Online Comment

Application H03-1262-18
Location Land off St Nicholas Way Deeping St Nicholas Spalding
Proposal Village Hall with associated car parking

Name Steve Branson
Address SHDC Priory Road

Date Submitted 26-03-19
For/Against Comments

Drawing title
Proposed Block Plan

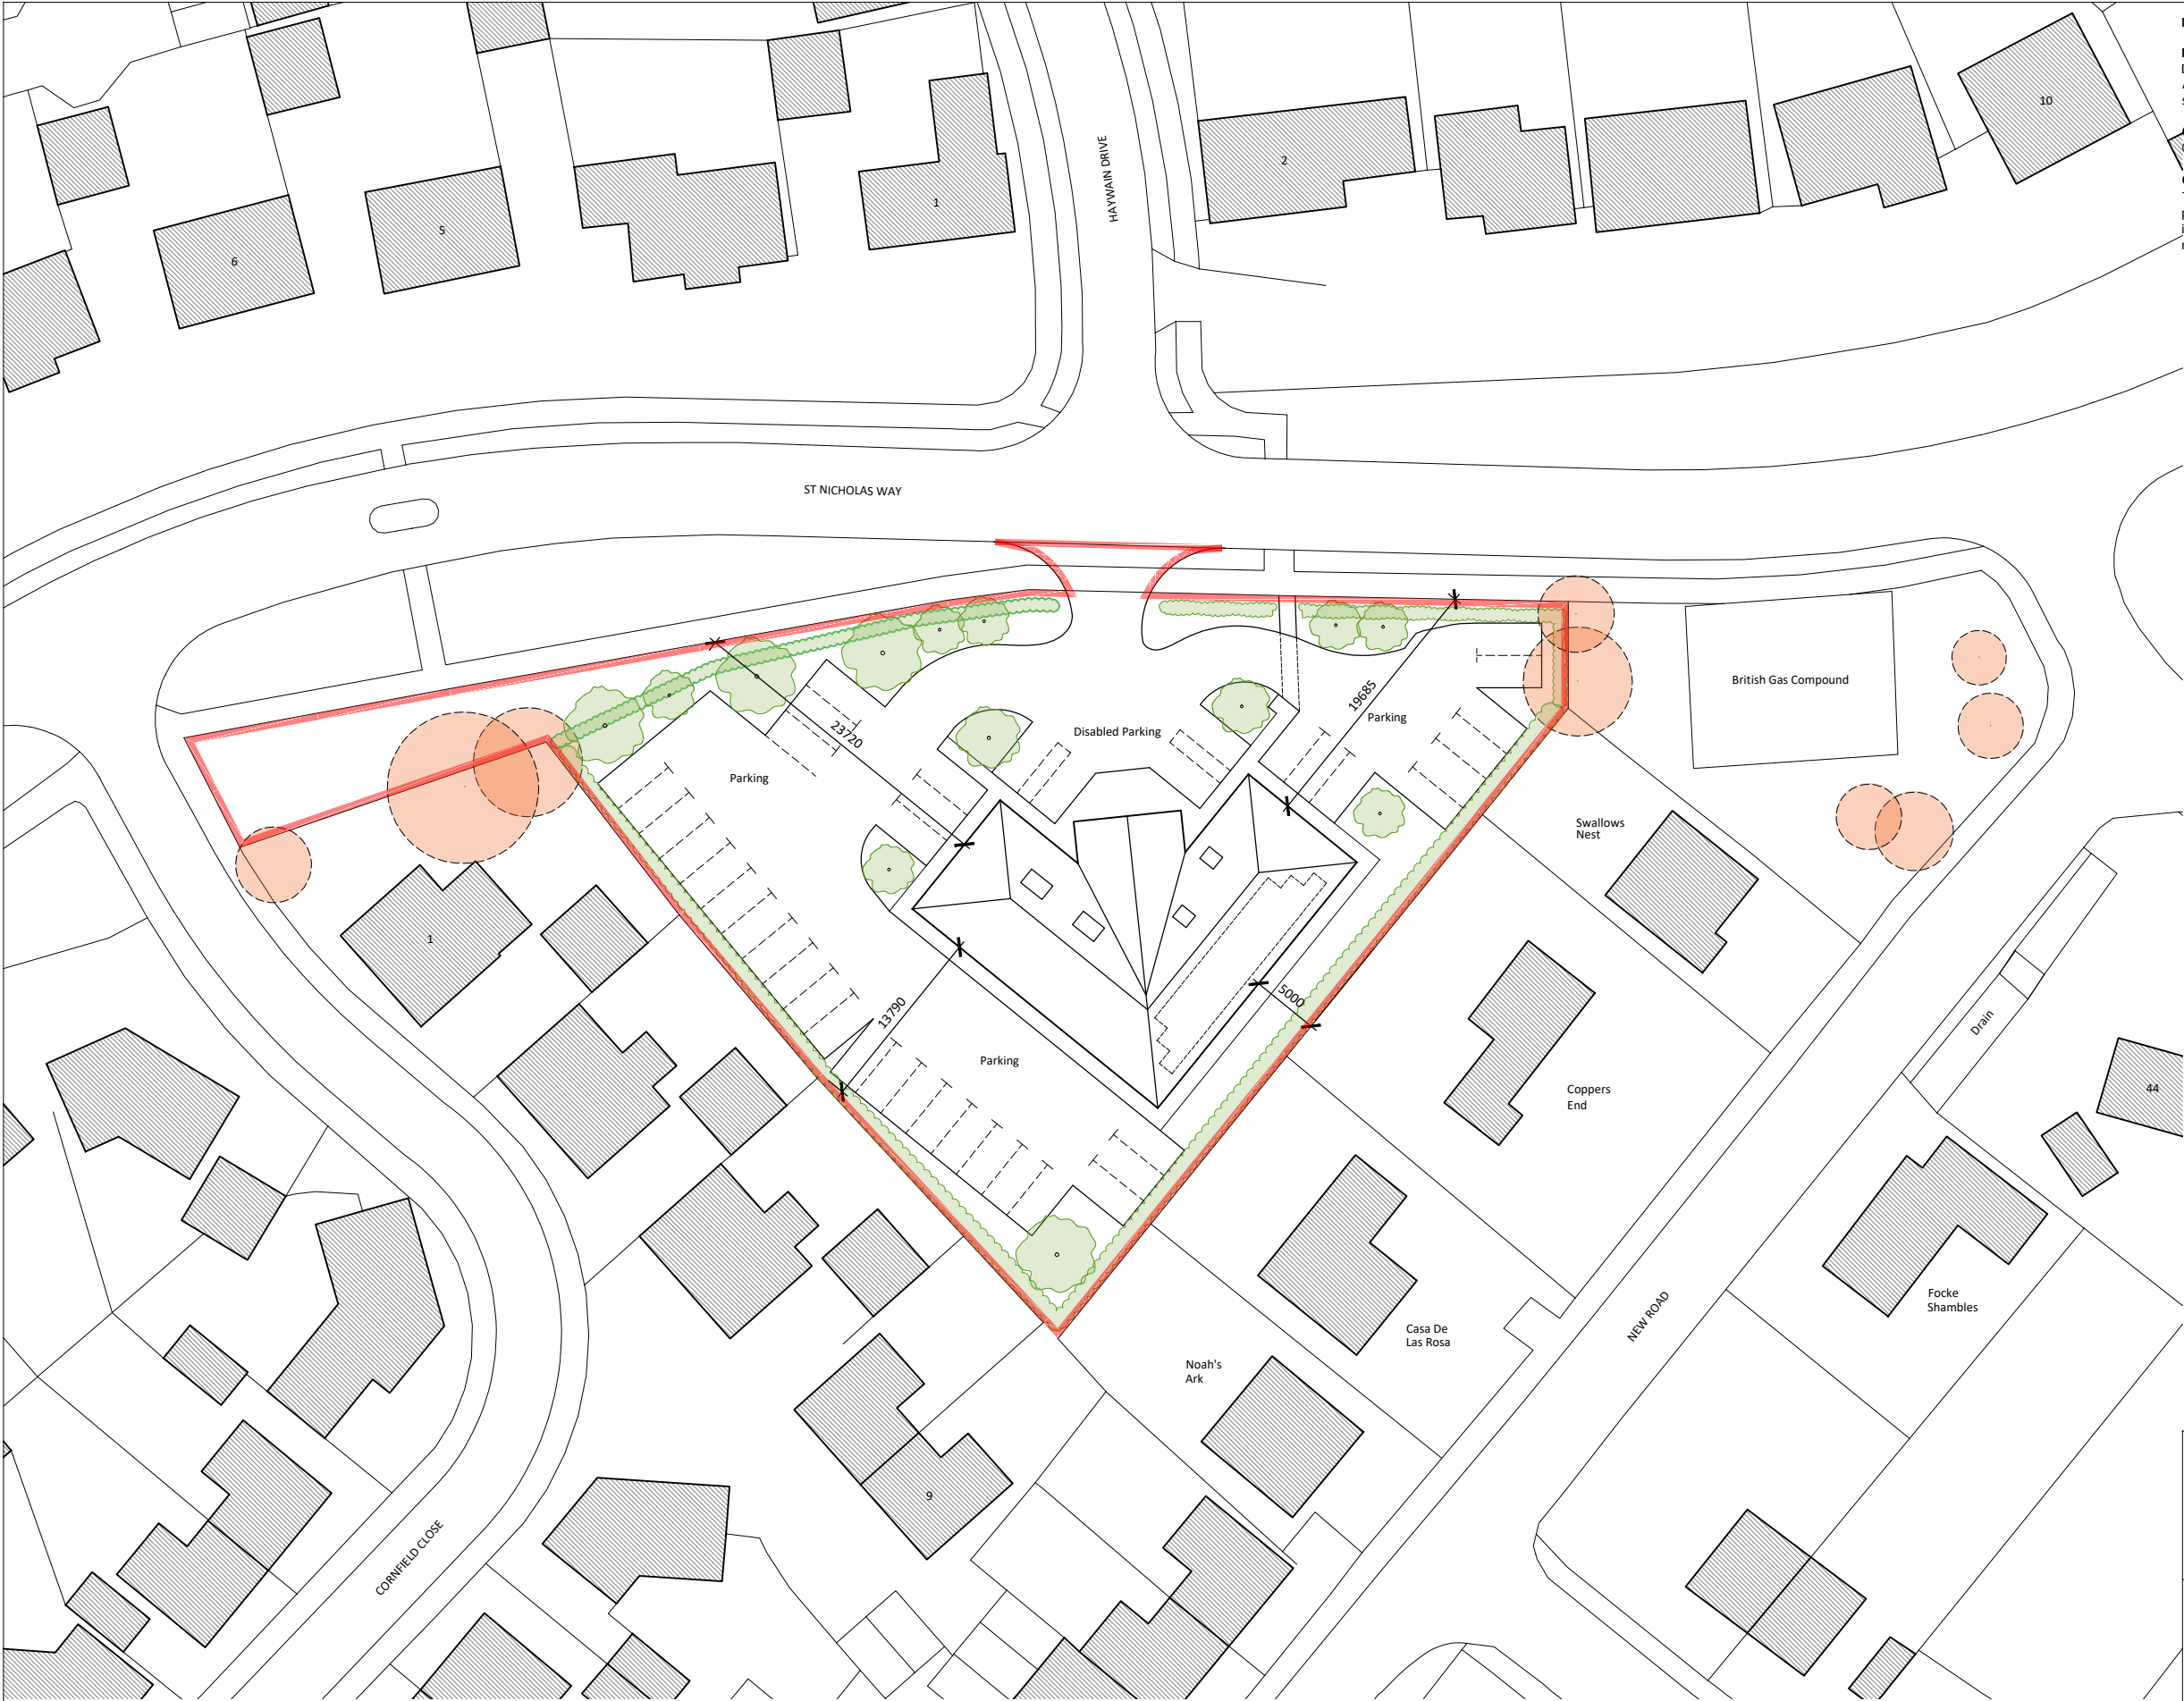
No objection in principle however I am concerned about the proximity of neighbouring residential properties.

It is important that the design and construction of the building takes this into account with regard to control of potential noise emissions.

If the premises requires a licence there may be additional noise control measures specified as part of the licence.
